Your ref: SSD10154

Subject: Notice of Exhibition – Qantas Flight Training Centre – SSD 10154

EES comments on Notice of Exhibition – Qantas Flight Training Centre – SSD 10154

Figure 24 Tree Removal, Retention & Replacement Plan

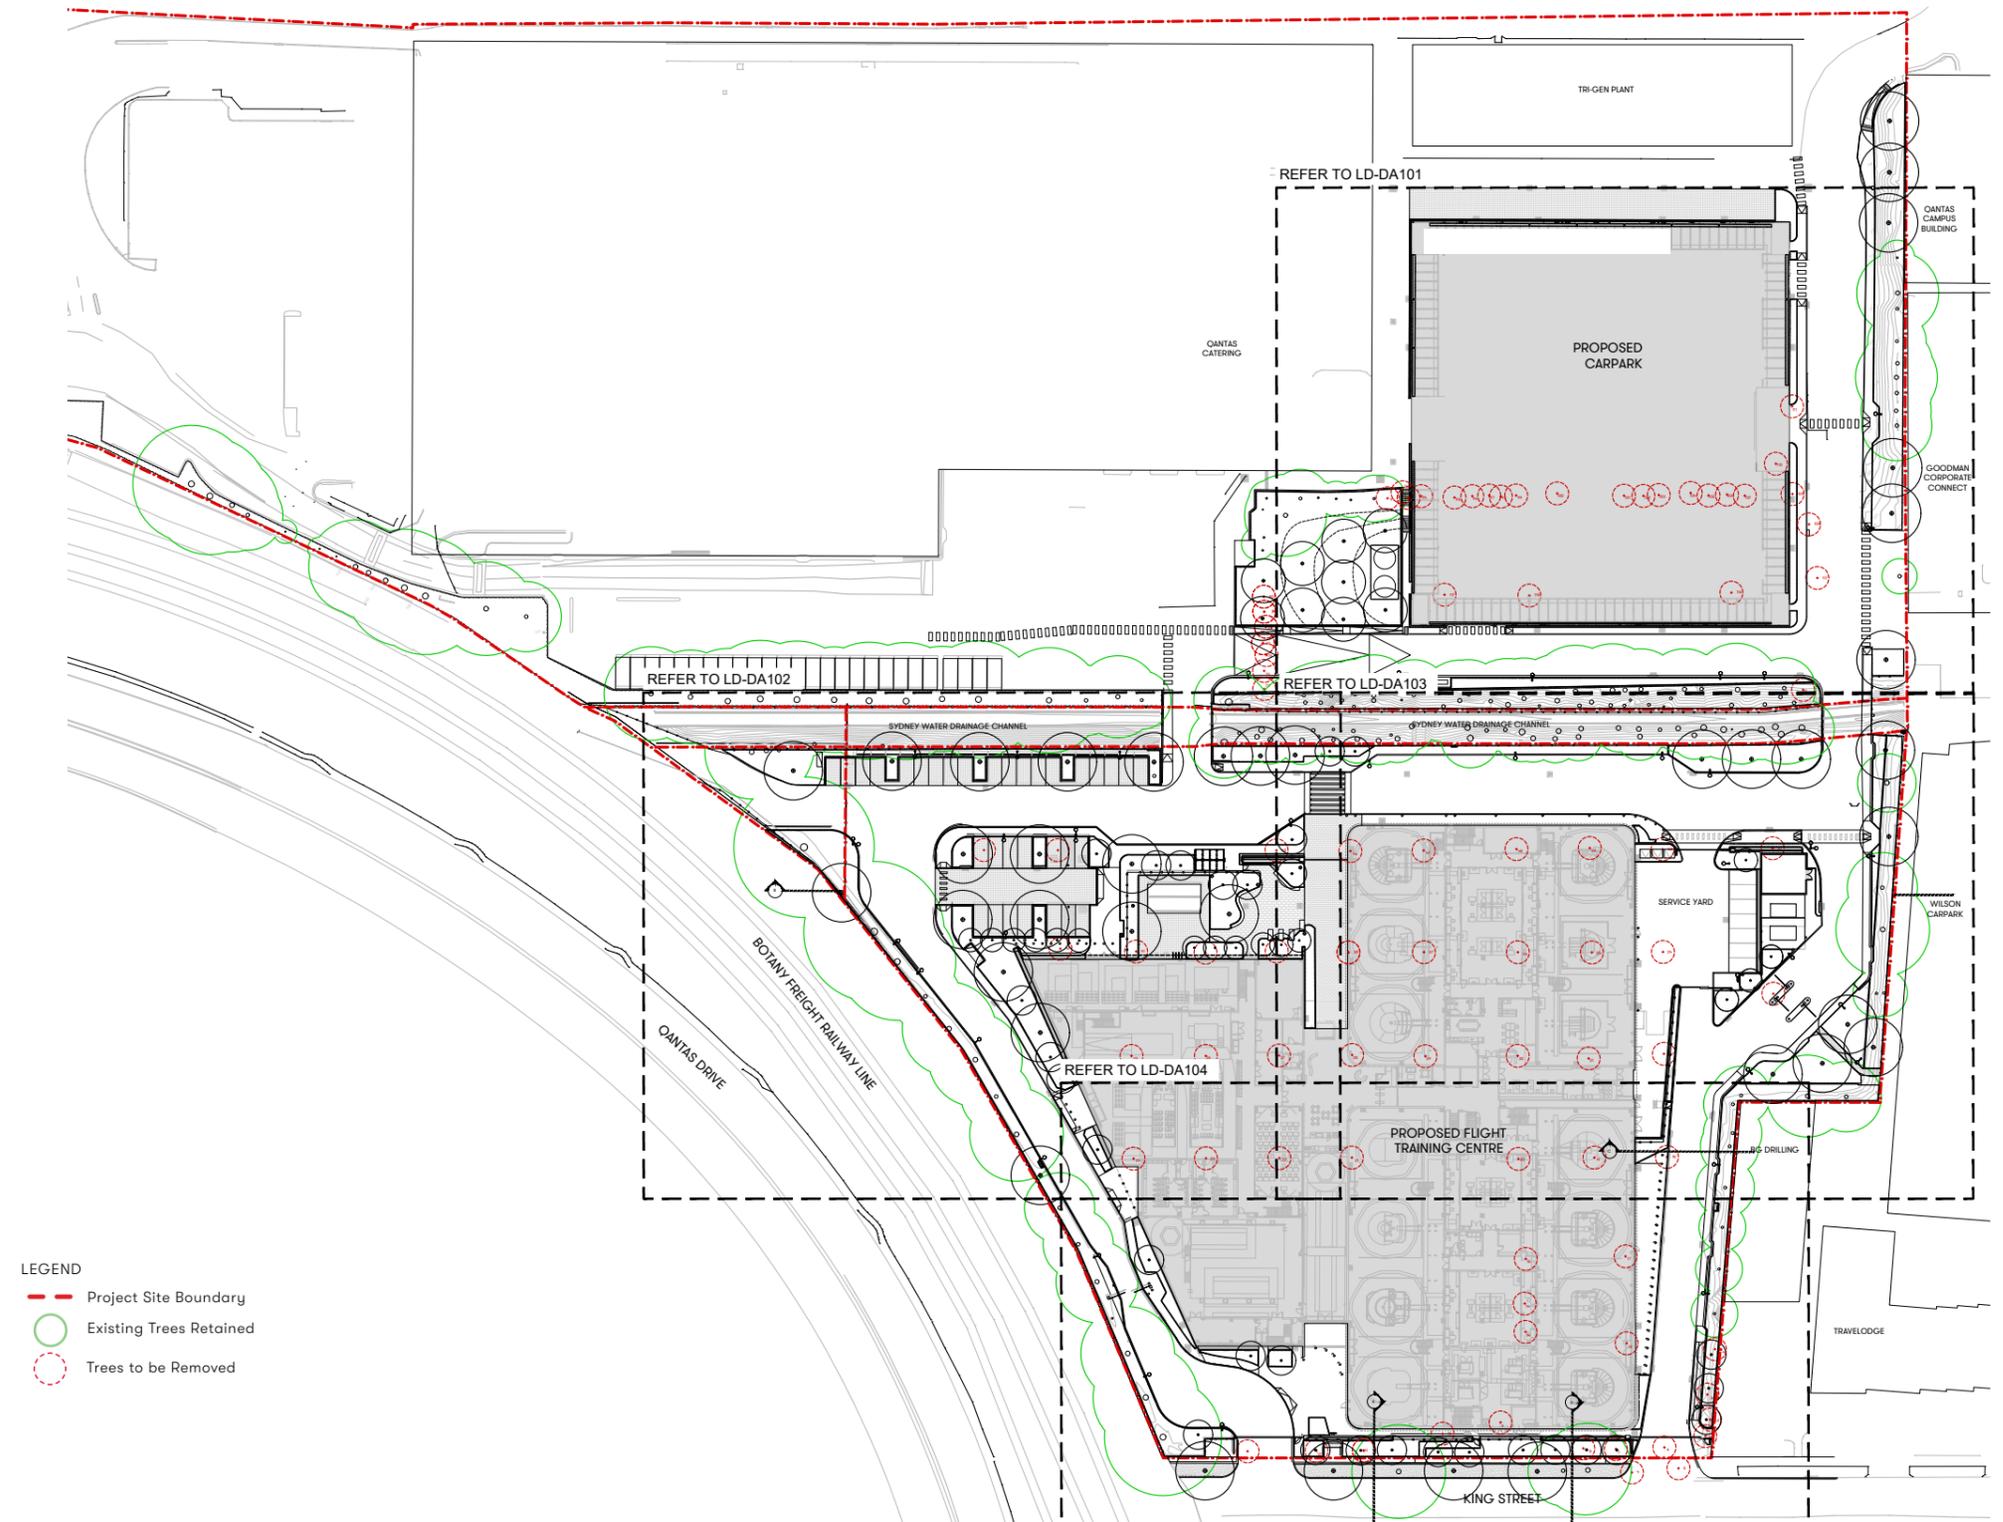
The EIS notes the project requires the removal of 85 trees (section 3.2.9, page 31). It recommends replacing as many of these trees as possible (section 7.5, page 100) and proposes to plant 68 new trees (section 3.2.9, page 31). While the EIS notes most of the vegetation to be removed comprises exotic plants or planted non-indigenous native species (see section 7.4, page 97), EES recommends that to assist mitigation of the urban heat island effect at the site and to improve the urban tree canopy and local habitat that the development:

- first avoids removing the trees where possible, particularly local native species
- replaces any removed trees at a ratio greater than 1:1

- replaces trees with local provenance native plant species from the local native vegetation communities that occurred in the local area to enhance local biodiversity, rather than use non-local native or non-native plants.

The proponent should provide details on the native vegetation community that occurred in the local area/on the site and demonstrate to the Department that the list of plant species to be used on site are local native species from the relevant vegetation community.
